Your Ref: OWPC3413
Our Ref: EP/95/14/HH 23-05-2014
Please ask for:
Mr D Sullivan

Town & Country Planning Act 1990 (as amended)

Demolition of existing garage (front), side entrance & toilet (single storey) & rear conservatory. New single storey garage & front porch. Single storey extension to west elevation & single & double storey rear extension. Resubmission of EP/144/13/
91 North Lane East Preston

BLOCK PLAN

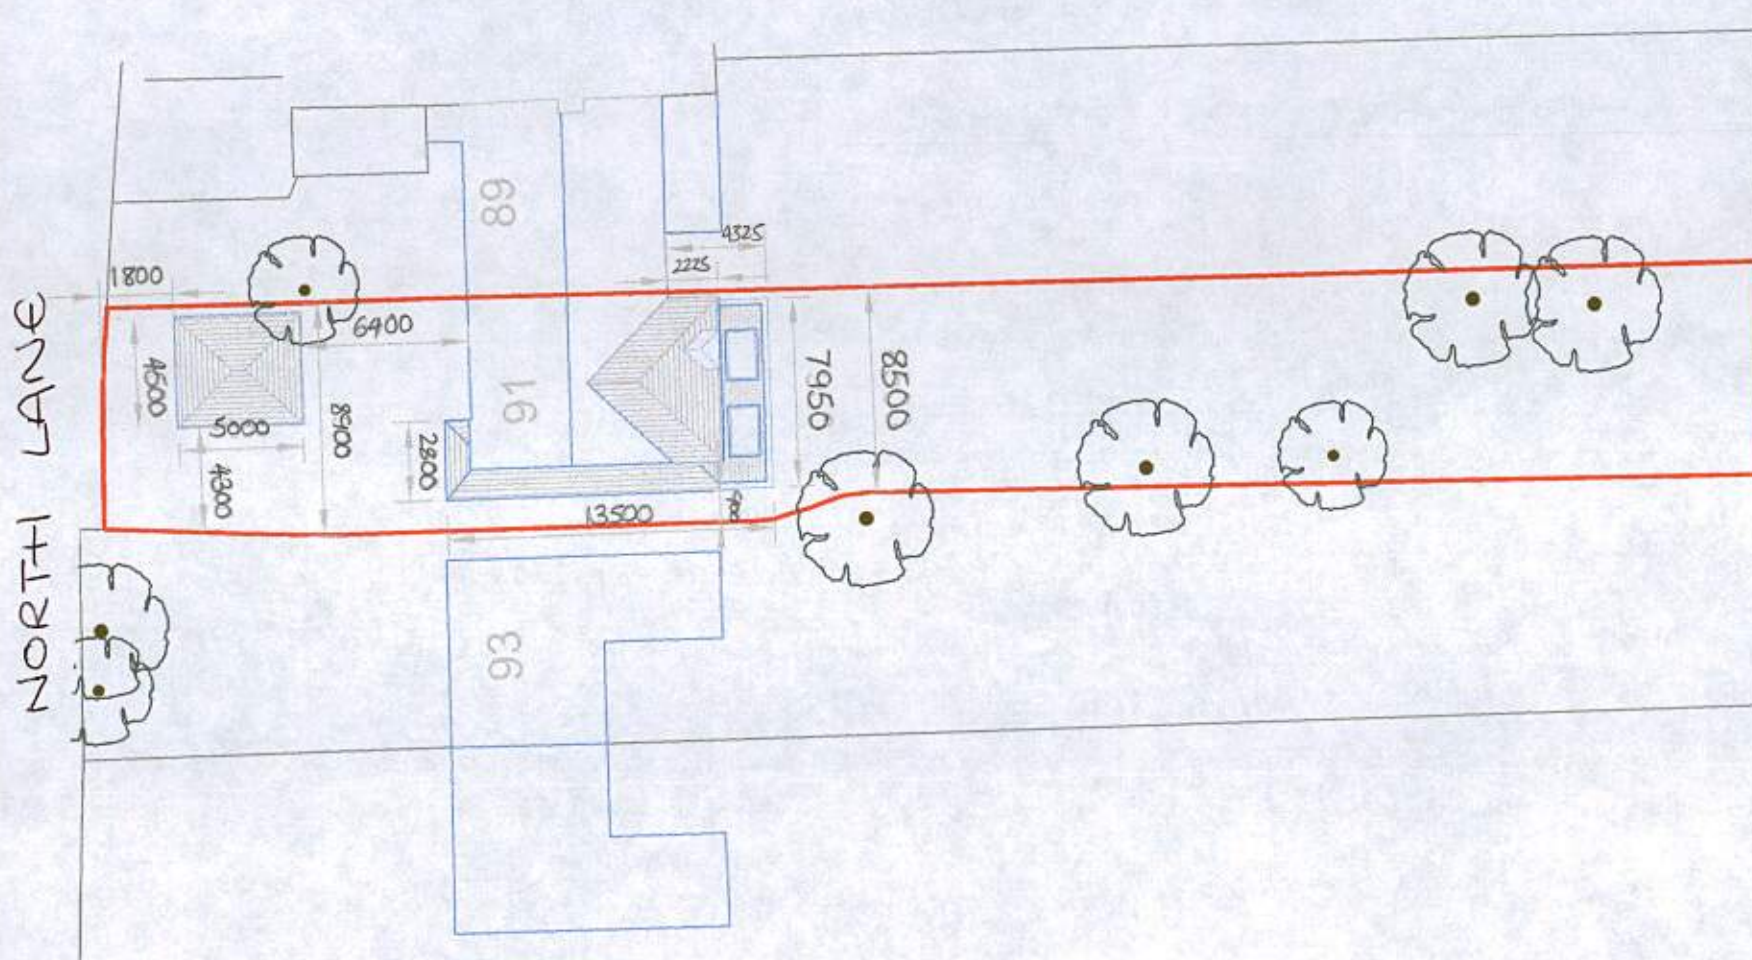
Please note again that the site plan submitted by Mr Hazzard does not show the full extent of my father's annexe at the back of the property and is misleading on the plans submitted showing the proposed development in conjunction with the annexe! The length of the annexe is approximately 9 metres and a single storey building with windows all the way down the side facing the proposed extension next door.

Elevations

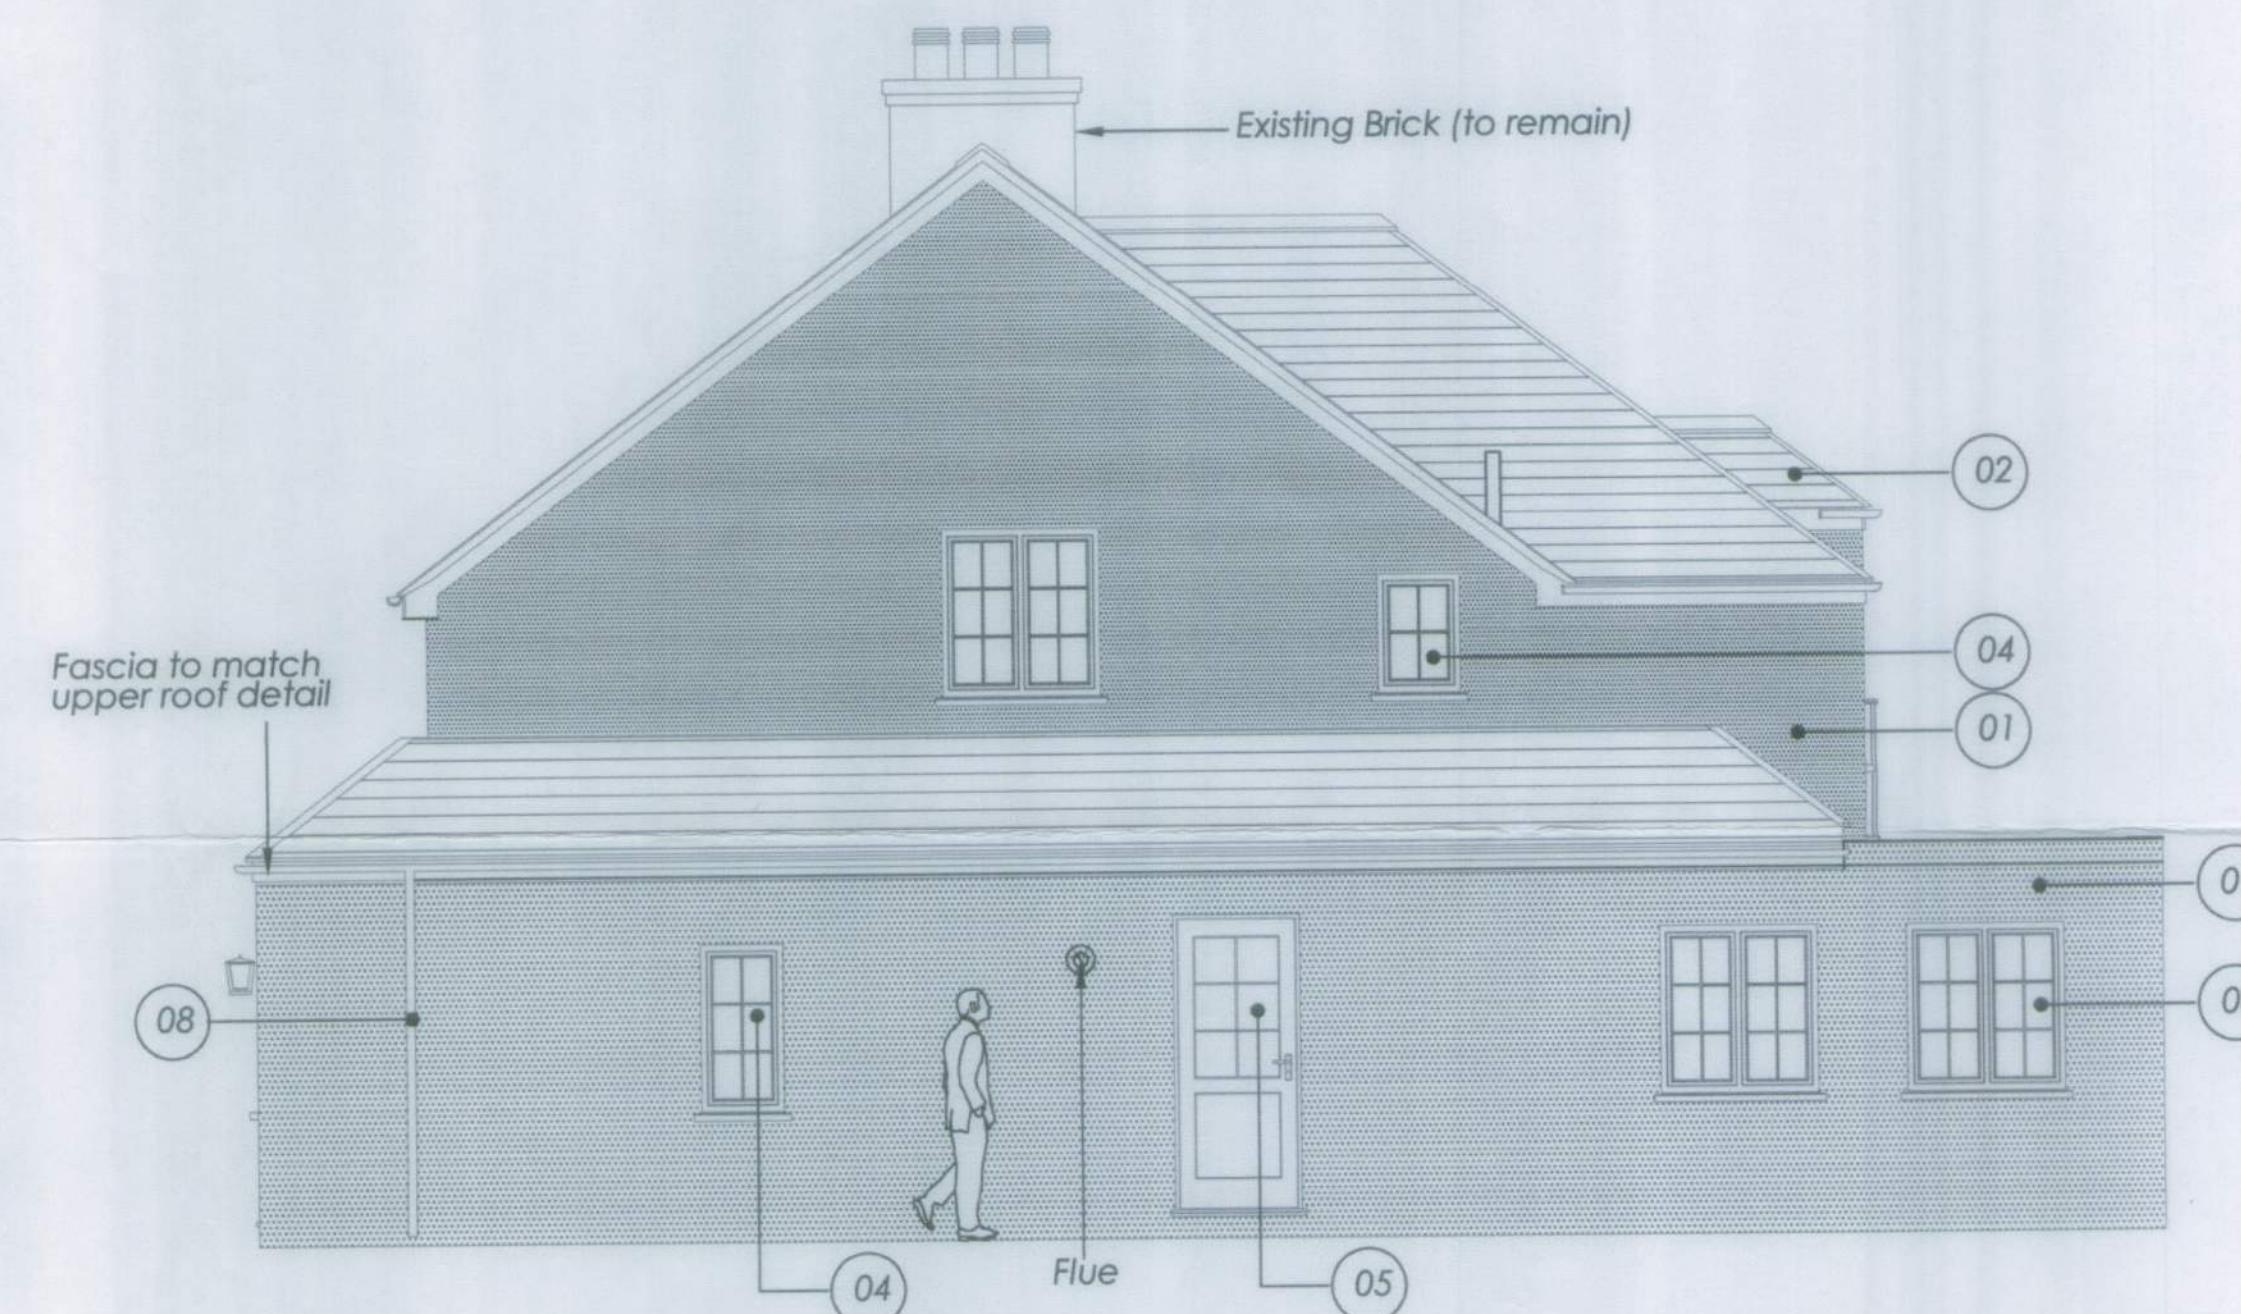
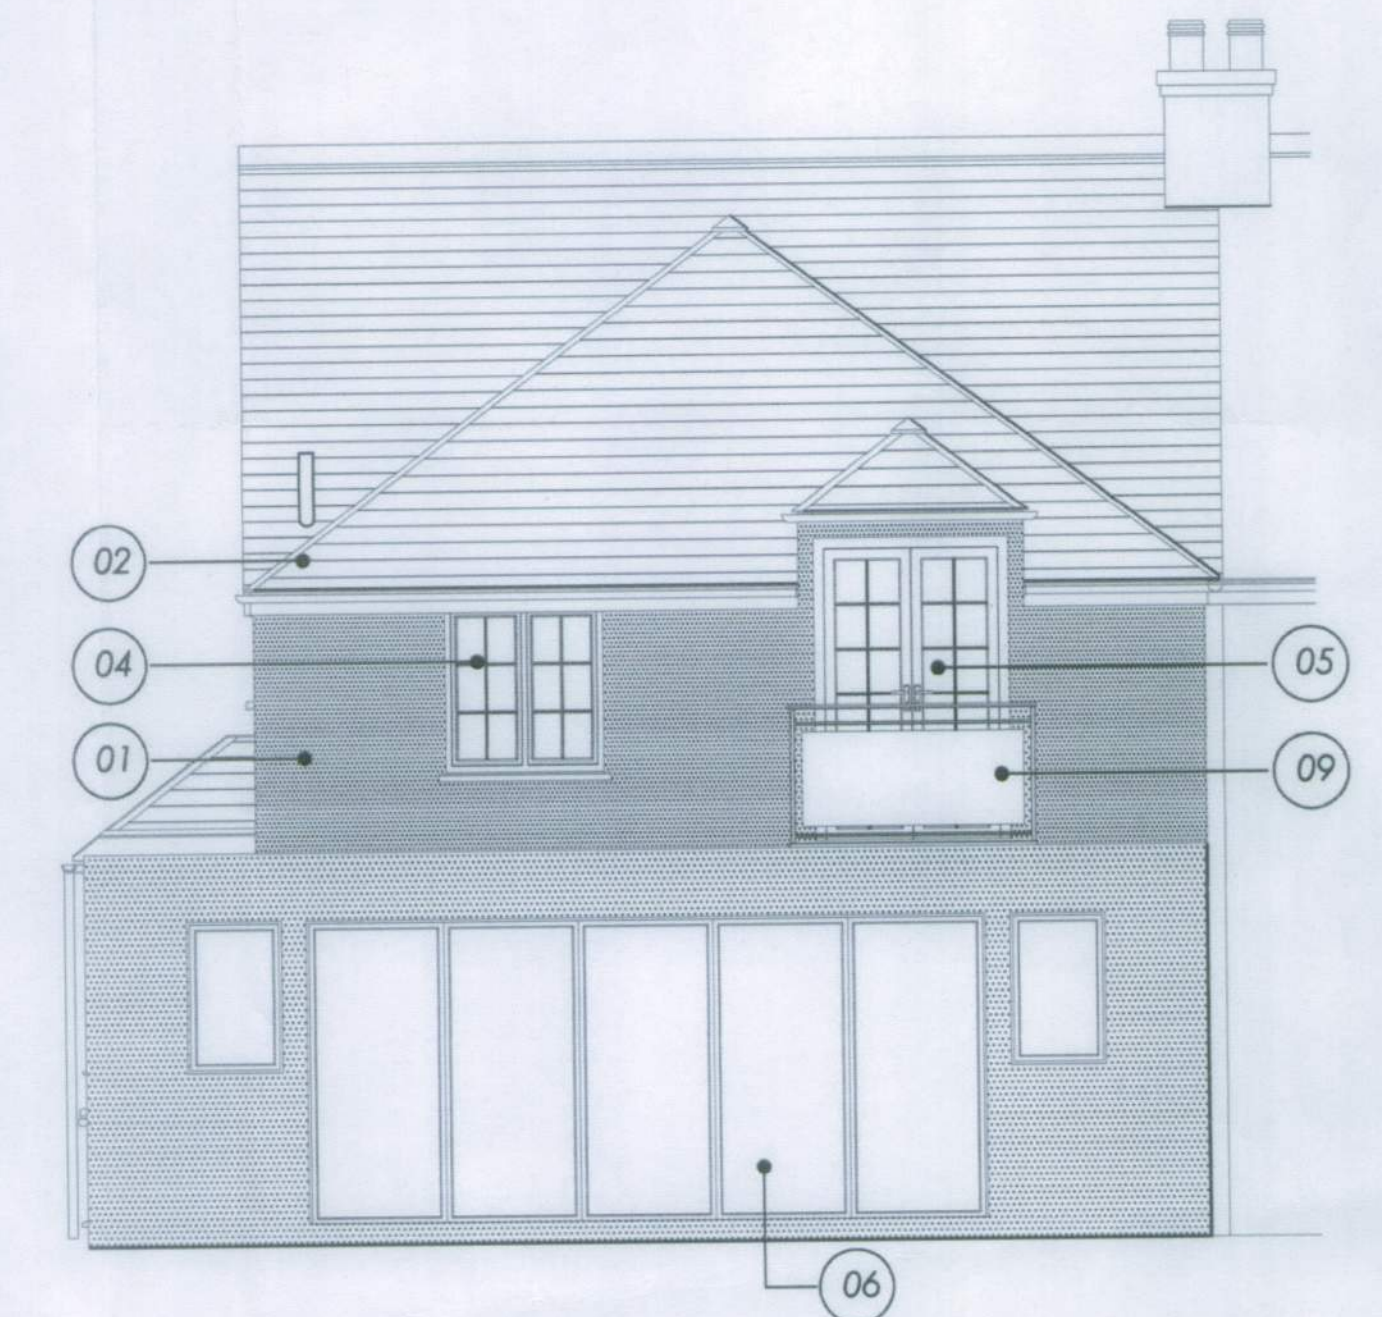
Our main objections are to the double height wall, its proximity to the boundary and the overhang of the roof, and the lack of light to both properties will still be invasive and for these reasons we will not be happy for the proposed building works to go ahead.
